CITY OF ALBUQUERQUE

April 30, 2018

RE: **Entertainment Facility**
3930 Pan-American NE
Grading and Drainage Plan
Engineers Stamp Date: 3/9/18
Hydrology File: G16D145A

ENGINEER'S SEAL	ENTERTAINMENT FACILITY 3930 PAN AMERICAN FRWY GRADING PLAN	DRAWN BY pm
		DATE 3-20-18
		DRAWING
	 <i>TIERRA WEST, LLC</i> 5571 MIDWAY PARK PL NE ALBUQUERQUE, NEW MEXICO 87109 (505) 858-3100 www.tierrowestllc.com	SHEET # 3
RONALD R. BOHANNAN P.E. #7868	JOB # 2017042

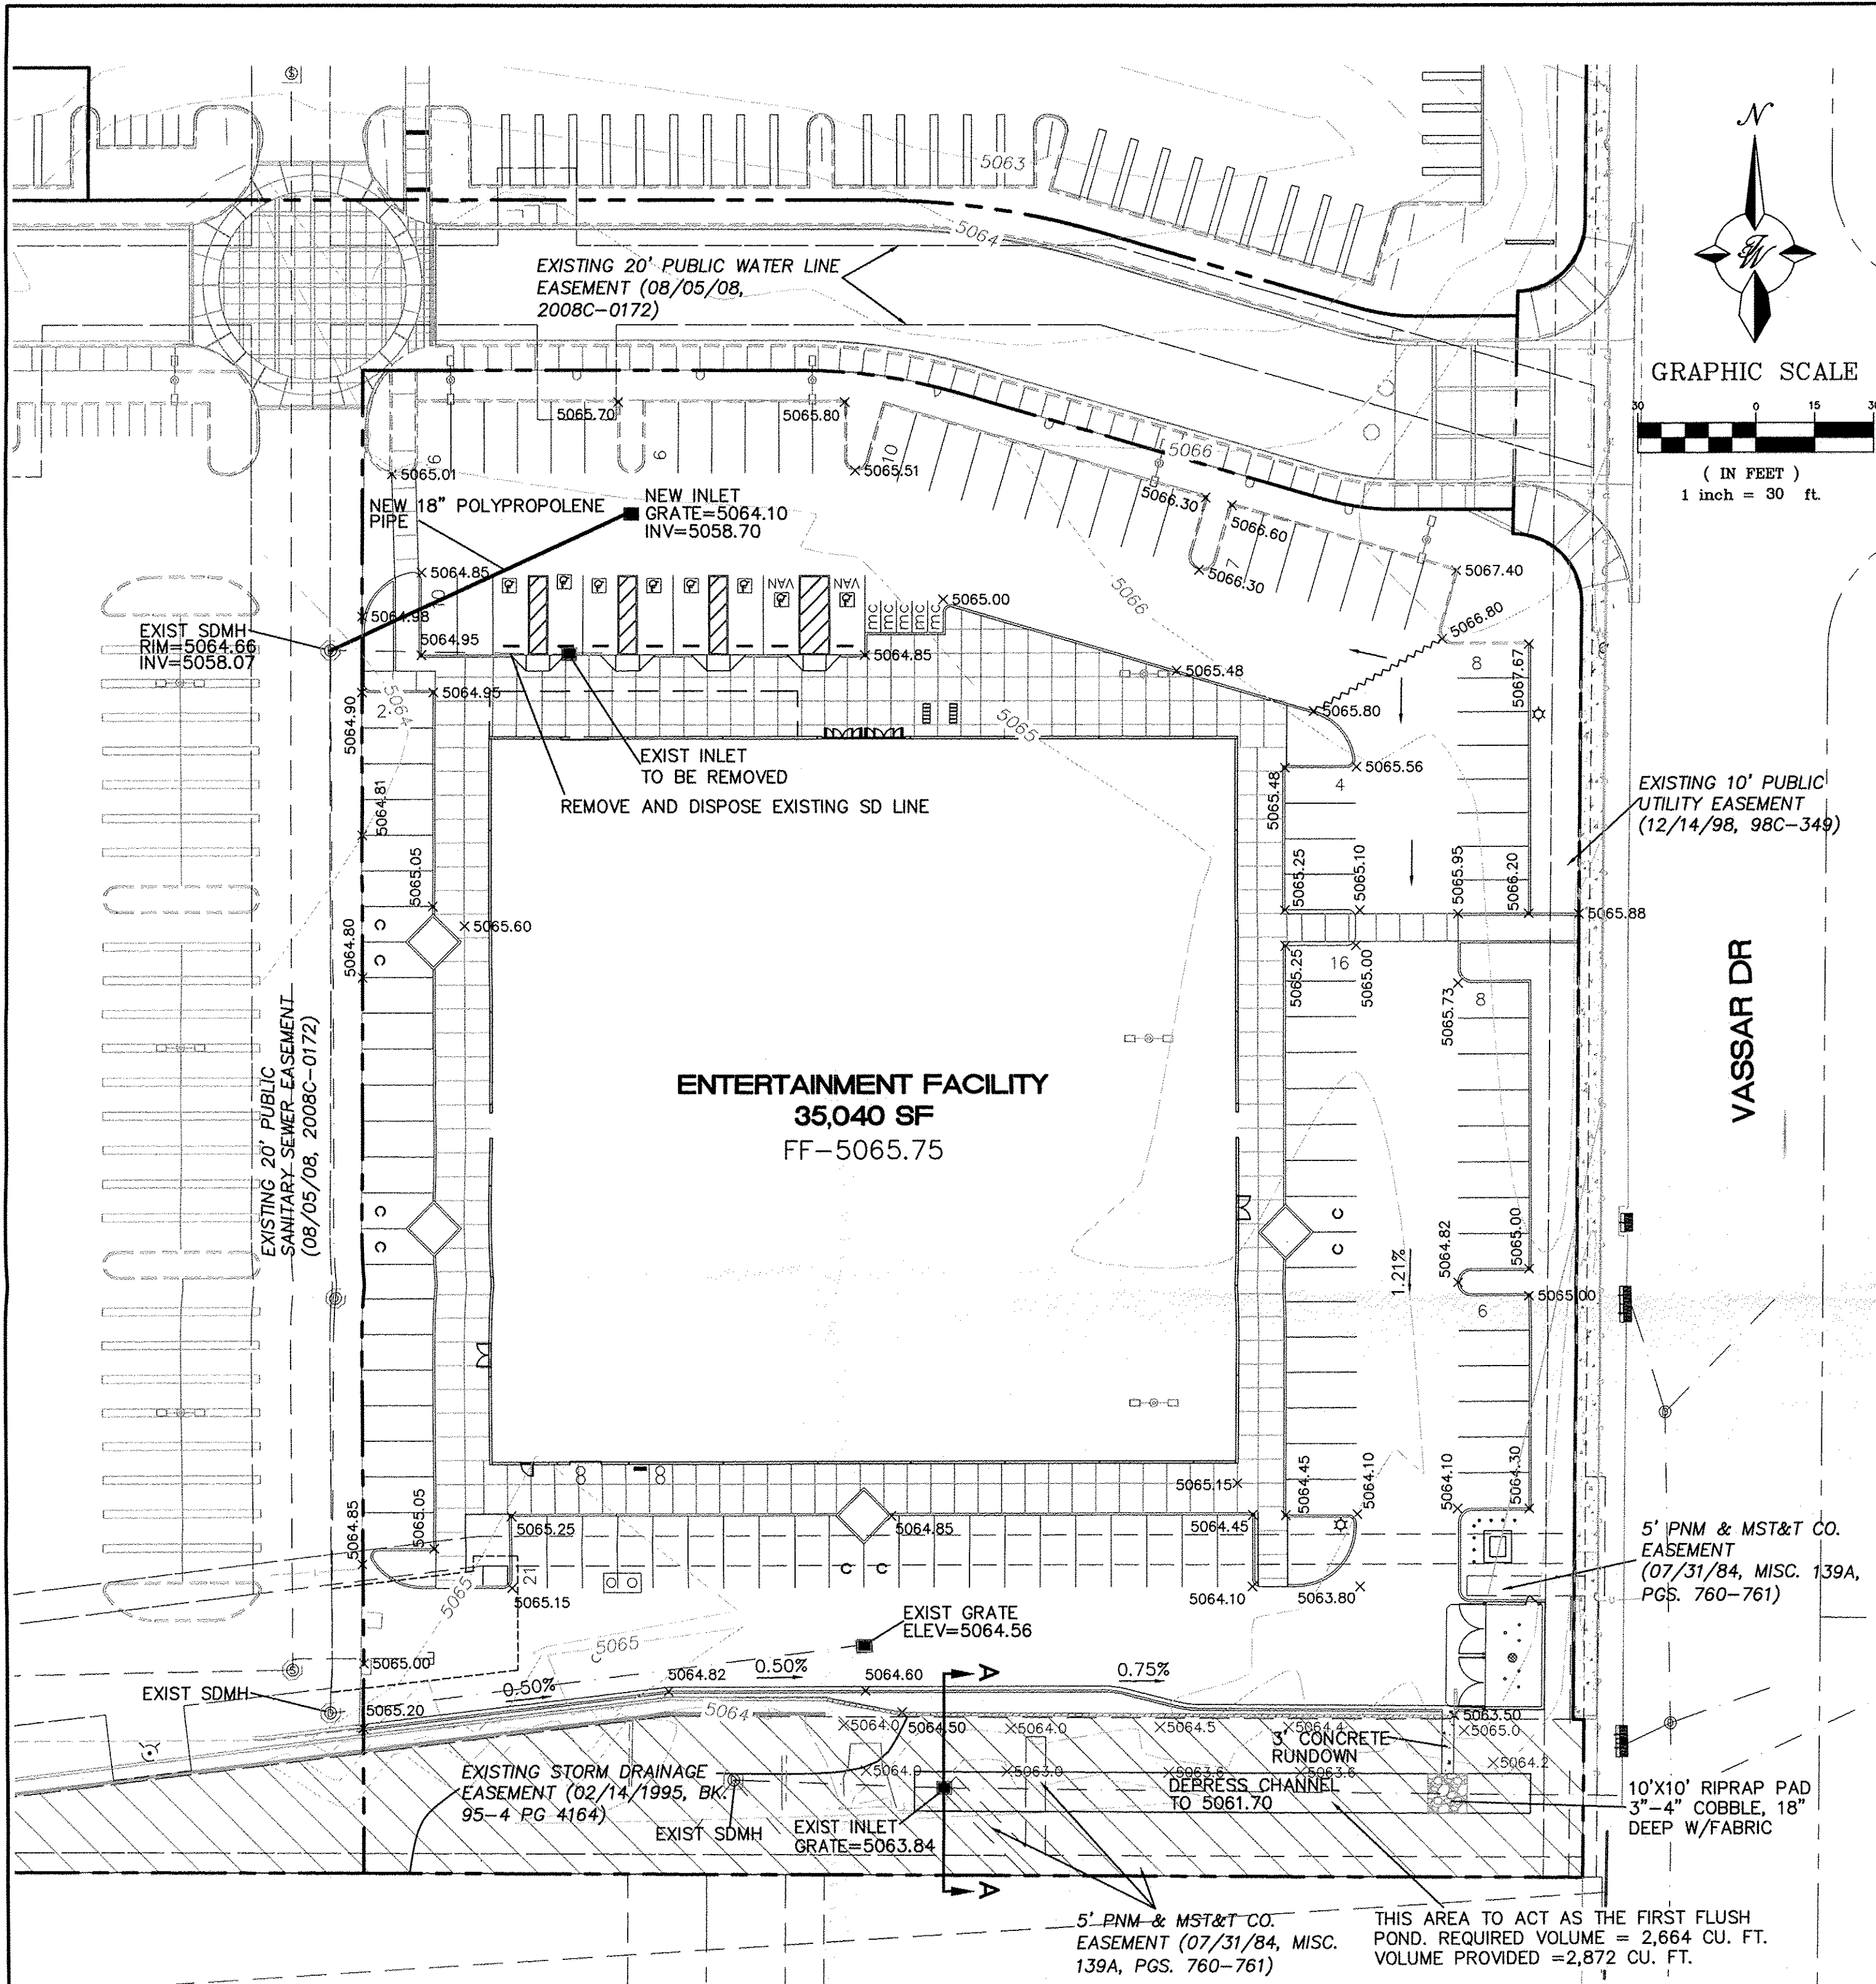
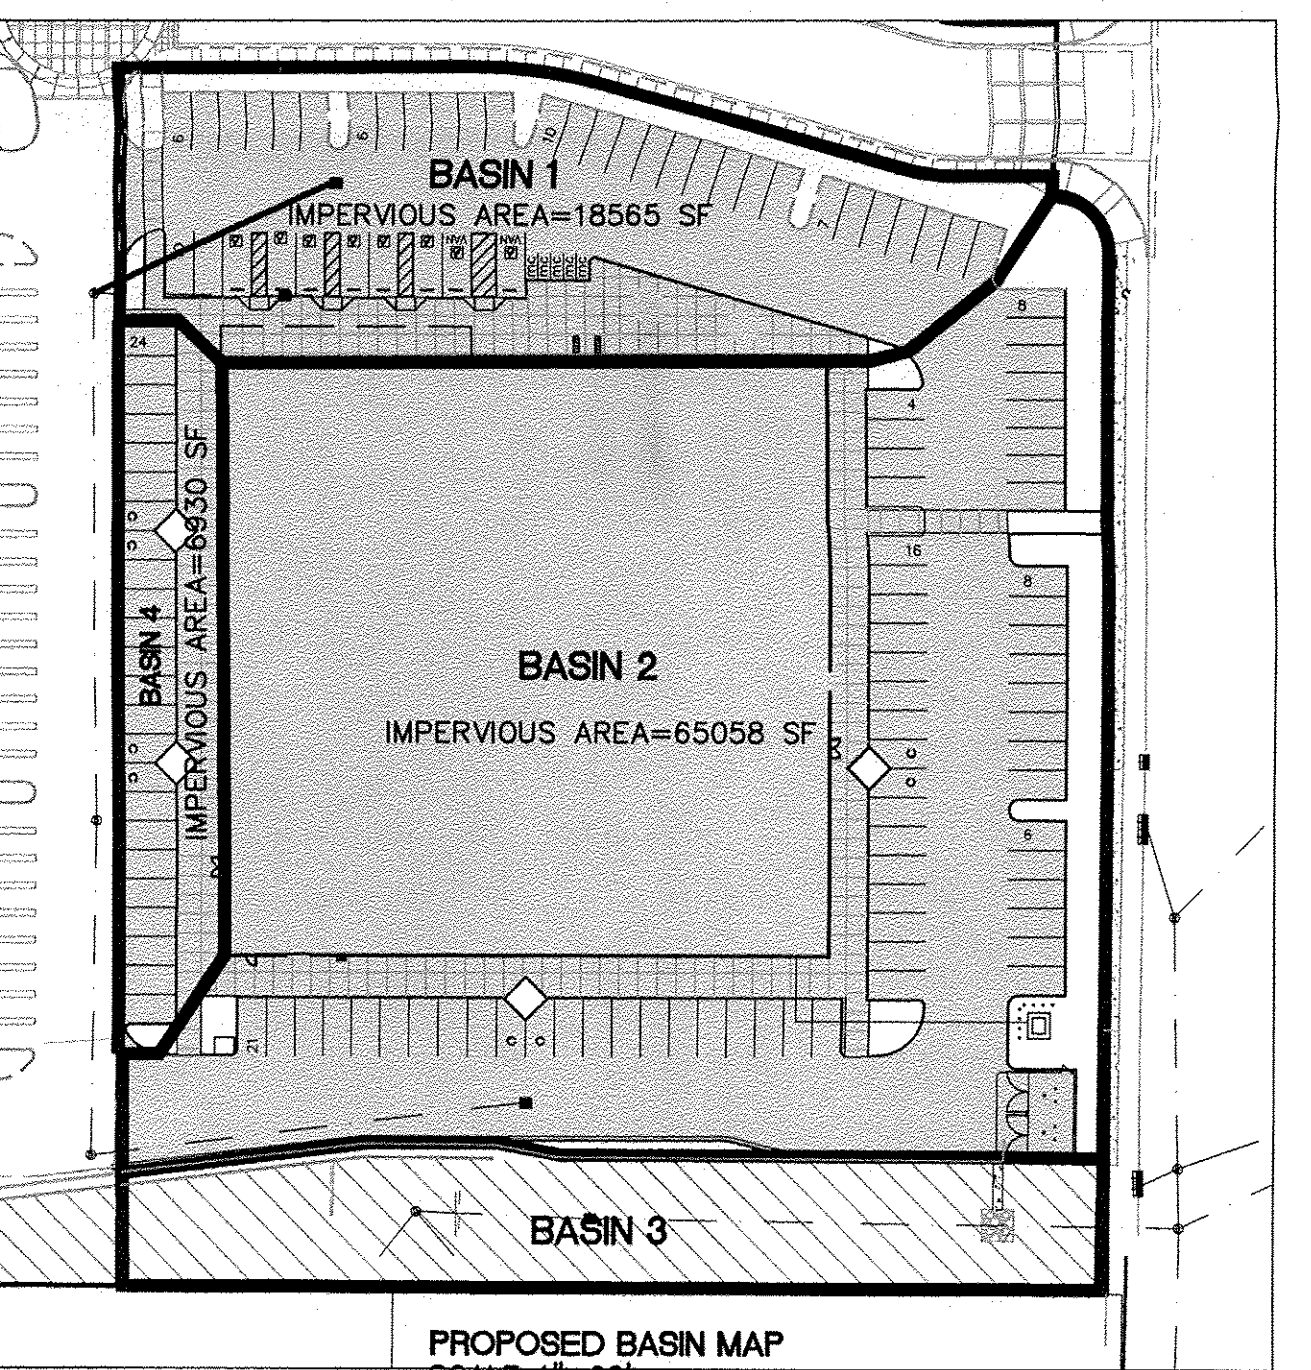
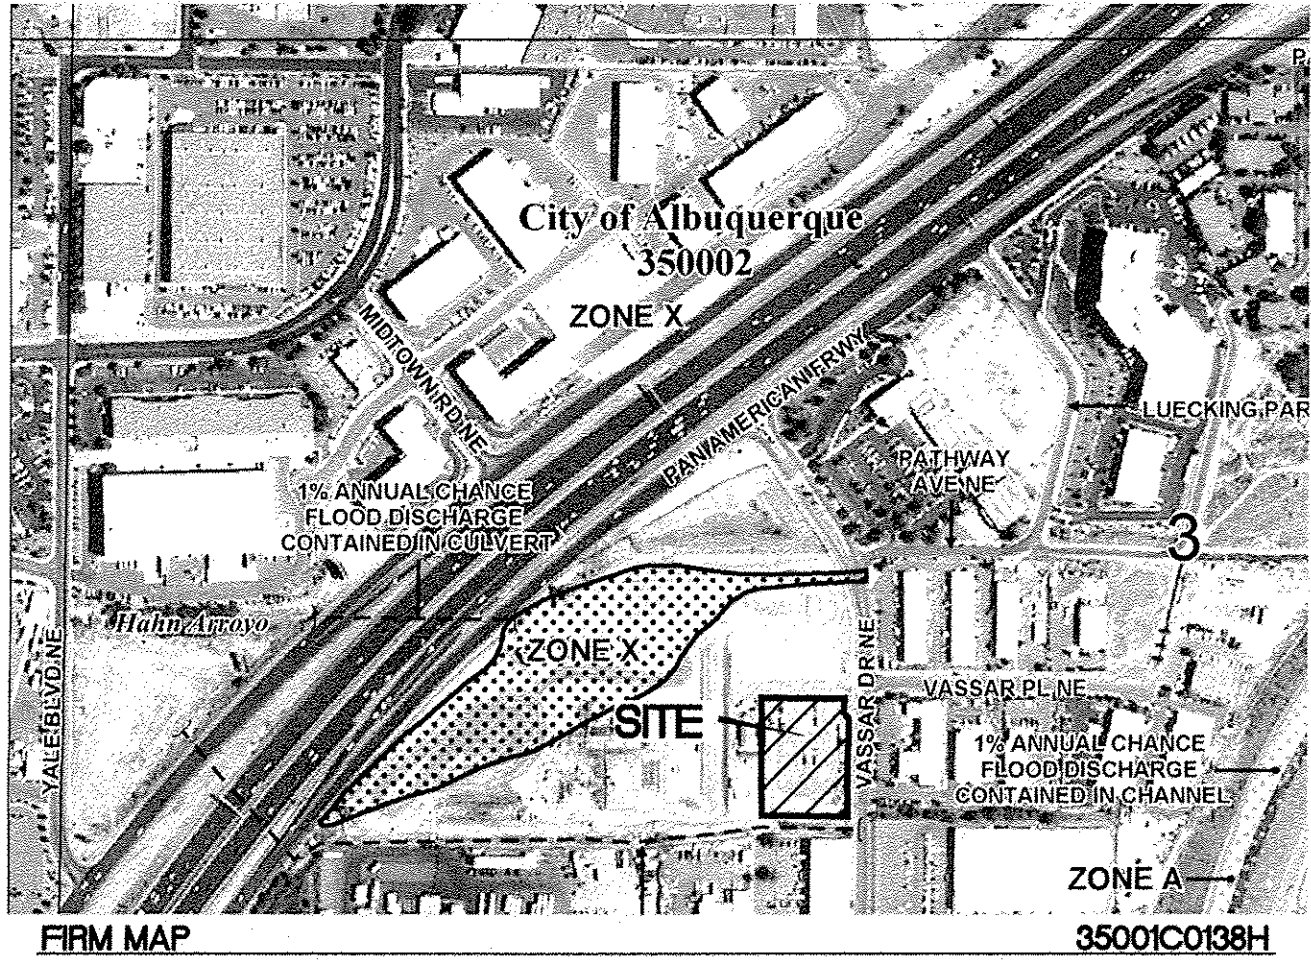
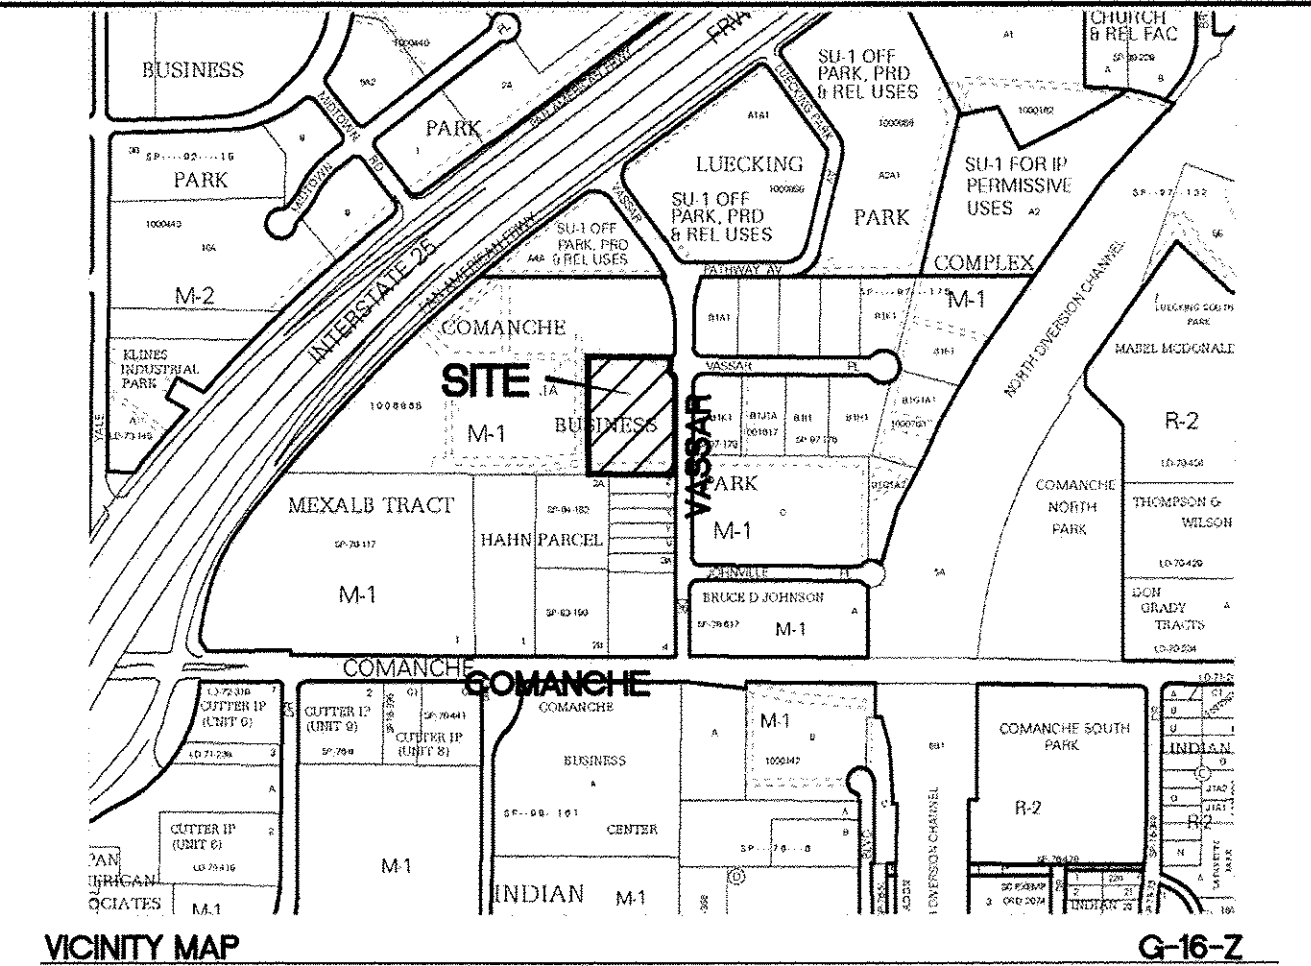
1. The "Proposed Site Drainage" narrative must be revised to clearly indicate the difference between "First Flush" and "Storm Water Management" requirements by adding a statement "The Griegos Pond (aka Edith Basin #2, aka SAD 216) is a detention pond and does not provide any first flush retention, nor was any other first flush retention provided with the previous phases of the Carpenters Center development."

2. The first flush requirements apply to all of the new impervious area on this site. Each pond should be sized for the impervious area draining to it. The City doesn't give credit for extra volume in a pond over and above that which is required for the impervious area draining into it. Fee in lieu of construction is allowed for any required volume not provided. We occasionally allow treatment of pre-existing impervious in lieu of treatment of new impervious as long as the pre-existing impervious is part of the same development. This procedure has been followed by all of the rest of the engineers on all of the rest of the projects in the city for the past year and we are not going to make an exception for this development. Treatment of the adjacent public street in lieu of treating the new onsite impervious is unacceptable especially in this situation where none of the first flush from the street will make it past the existing inlets on either side of the rundown into the pond. The rundown plan view, details, and narrative must be removed from the plan.

3. First Flush volume calculations, both required volume and provided volume, must be added to the plan for each pond, and more detail is required on each pond including proposed contours, dimensions and spot elevations. Both existing and proposed contours must be legible. The City will accept Fee-in-Lieu of first flush. Add the volume calculations for the portion of the first flush, if any that will be paid fee in lieu of construction.
4. An Agreement and Covenant is required for the stormwater quality pond on the public easement. The original notarized form, pond exhibit (legible on 8.5x11 paper), and recording fee (\$25, payable to City of Albuquerque) must be turned into DRC (4th, Plaza del Sol) for routing. Please contact Charlotte LaBadie (clabadie@cabq.gov, 924-3996) or Madeline Carruthers (mtafoya@cabq.gov, 924-3997) regarding the routing and recording process for covenants.
